Application Reference: 2024/0988

Site Address: 15 Beech Avenue, Silkstone Common, Barnsley, S75 4RH

This application seeks full planning permission for the removal of rear conservatory, erection of single storey side and rear extensions. The applicant informed the LPA that the client is also wanting to remove the artificial stone tiles on the front of the property and would like to render the rear extension, as such the application description has been amended after conferring with the applicant.

PROPOSED PLANS&ELEVATIONS

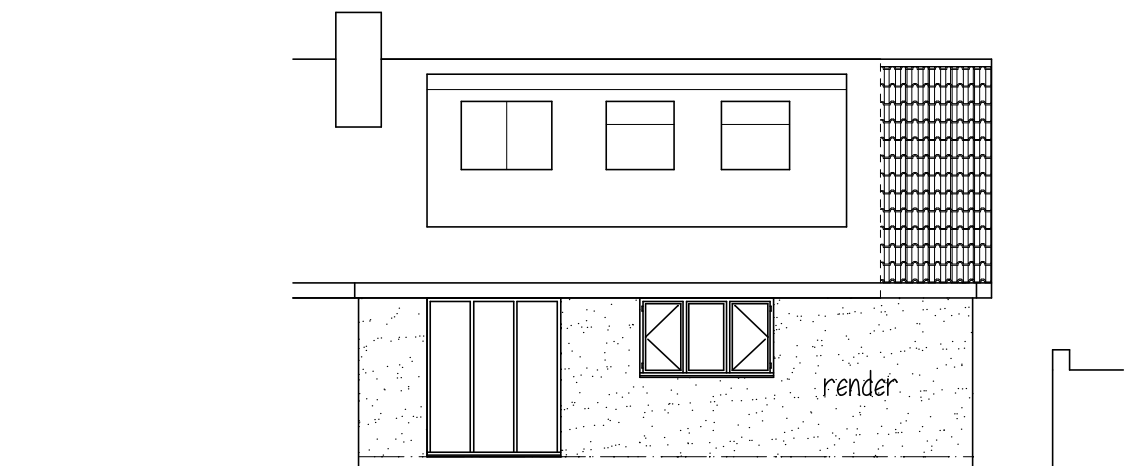
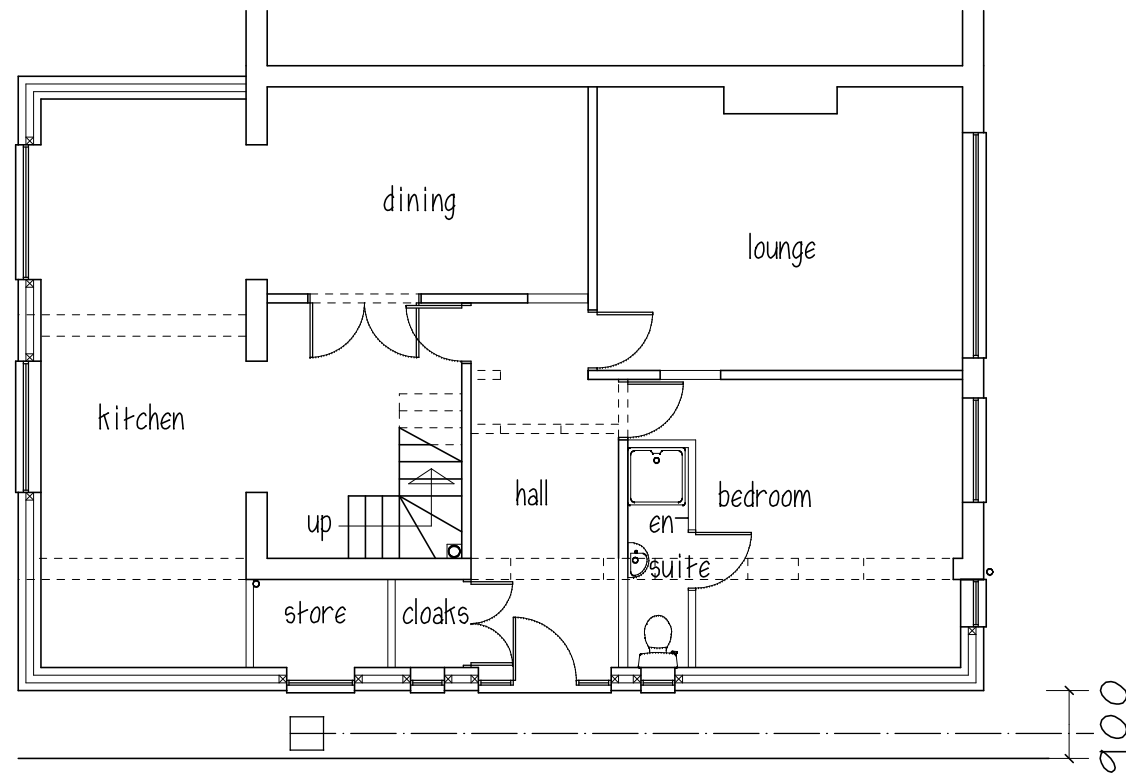
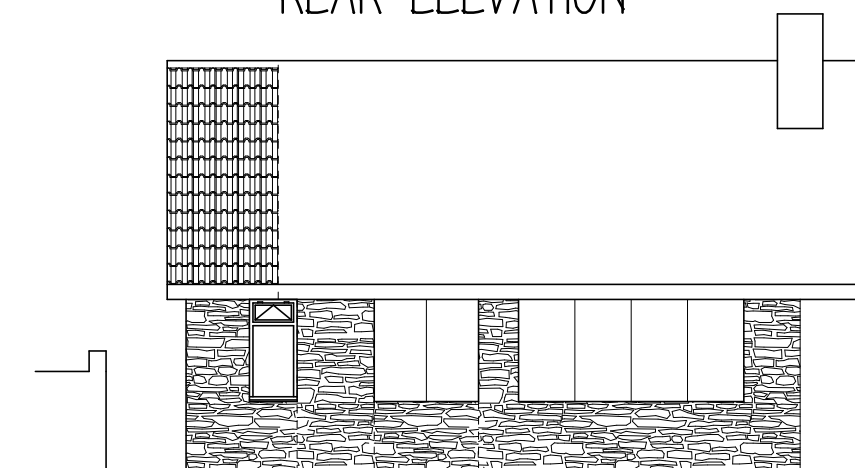
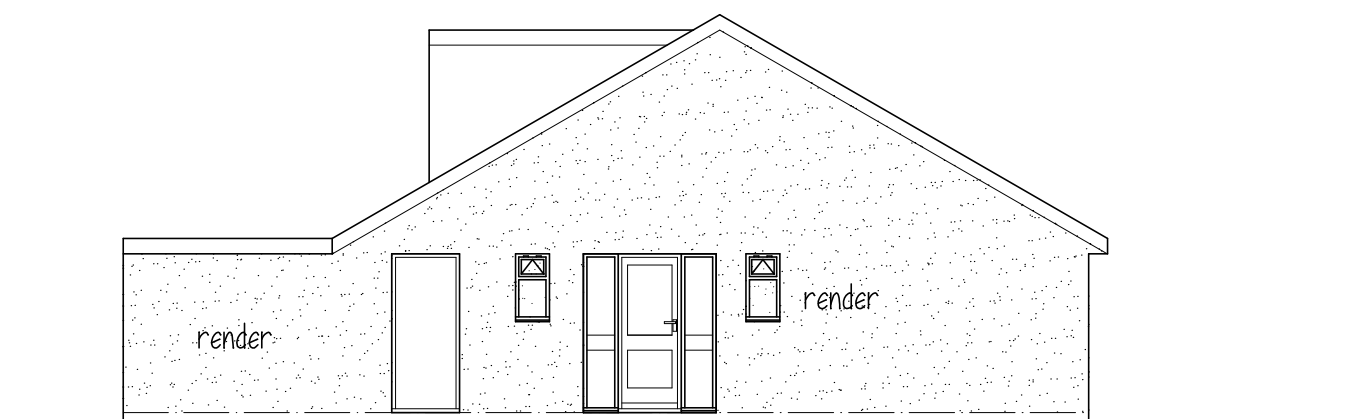
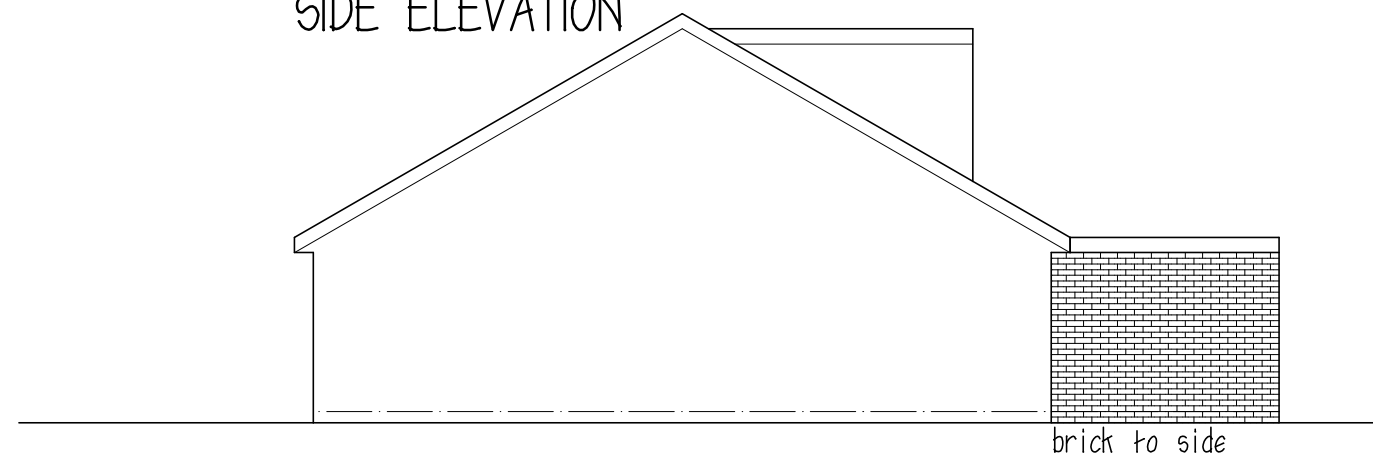
The scale of the proposed development is acceptable, however the applicant previously wanted to include render to the side of the property which could be seen from the road. This would have changed the street scheme and had a detrimental effect on the character of the area. The area is characterised by brick and stone properties, whilst it was noted that the applicant tried to argue that there are other properties in the area which have render to the front and sides. Whilst it is acknowledged that these properties exist the use of render is not widely used in this area, and after investigating these properties it was understood that they either achieved planning permission before the recent passing of the House extensions and other domestic alterations SPD or were over the statutory 10-year period. As such, the applicant was asked to amend the drawings to overcome the issue and compromise by using render only to the rear and to the new extension to the rear. This would not have a detrimental impact on the character of the area and would be out of view to the public.

It has been necessary to make contact with the applicant to request amendments to the proposal during the consideration of the application, as it was deemed acceptable. This was in the form of removing render to the front and side of the property, to keep the property in keeping with the character of the area.

The Applicant has stated that matching brick slips will be used to the side of the single storey side extension. Whilst render will be used to the rear extension.

Therefore, after negotiating with the applicant the changes have made the scheme acceptable, and it would be in keeping with the current character and street scene. A condition has been attached to ensure that the materials of the extensions match the materials stated on the updated plans.

The proposed side extension would result in the reduction in length of the driveway and the loss of access to the garage within the rear garden. However, the proposals include the creation of a new frontage parking area within the site which satisfies the off-street parking

requirement, and the spaces can be adequately accessed and egressed. The Council's highways Officer has therefore advised that the proposals do not adversely impact upon the highway and are acceptable from a highway's development control perspective, subject to the condition that access and parking facilities shall be surfaced in a solid bound material.
